**Our ref:** RA/2025/148983/02-L01  
**Your ref:** 2025/92882  
**Date:** 11 March 2026

**ERECTION OF 75 DWELLINGS WITH ASSOCIATED PARKING,  
INFRASTRUCTURE, HARD AND SOFT LANDSCAPING AND ACCESS FROM  
MANCHESTER ROAD AT CELLARS CLOUGH MILL, MANCHESTER ROAD,  
MARSDEN, HUDDERSFIELD, HD7 6LY**

FILE LOCATION PATH: P:\PROJECTS\HOT3884\CELLARS CLOUGH, MARSDEN\04 BIM\CIVIL\DRAWINGS\3884-CIV-XX-XX-D-C-1001 EXISTING CATCHMENT GA.DWG

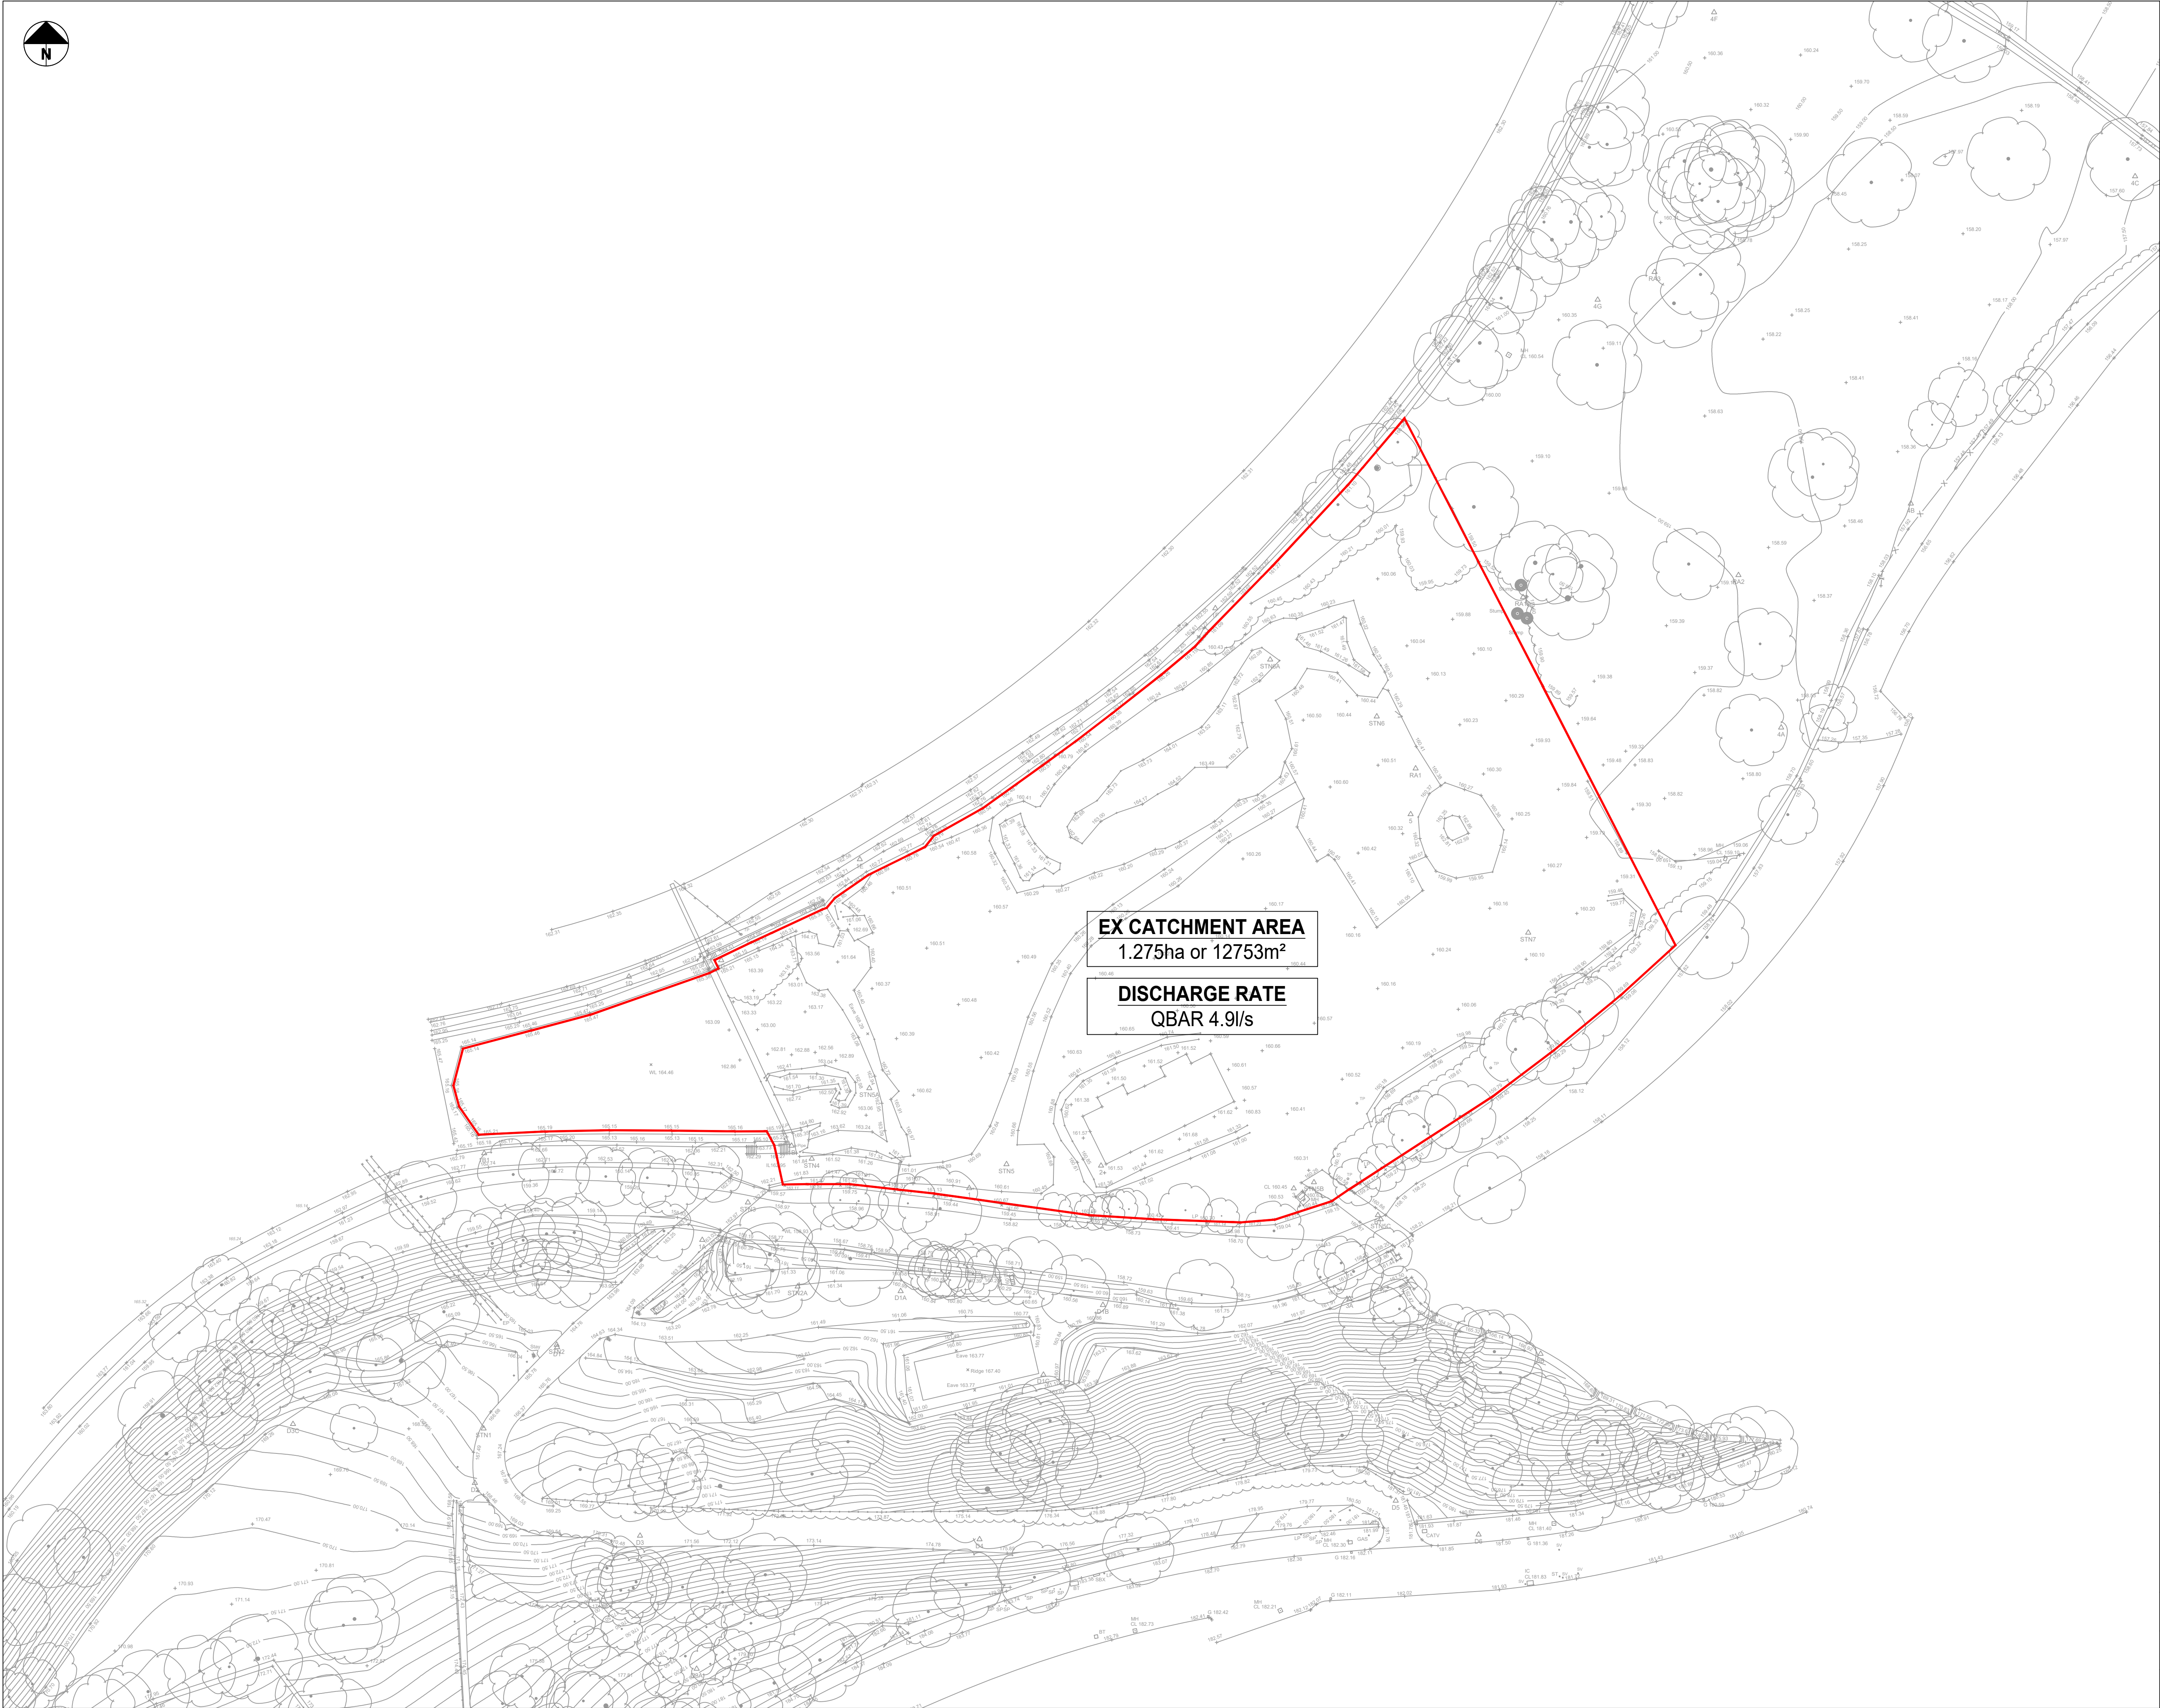
We understand from the FRA that the whole site will be raised above the design flood level. It is unclear how the compensatory storage requirements have been calculated. The FRA should be updated to demonstrate how hydraulically linked like for like level for level flood compensatory storage outside of the design flood event flood extent shall be achieved. The FRA currently only provides an indication where the compensatory storage might be located but does not provide any further details.

Please note, the current location for the proposed compensatory storage is within the design flood event flood extent and is therefore not considered suitable.

To overcome our objection, the applicant should submit a revised FRA which addresses the points highlighted above.
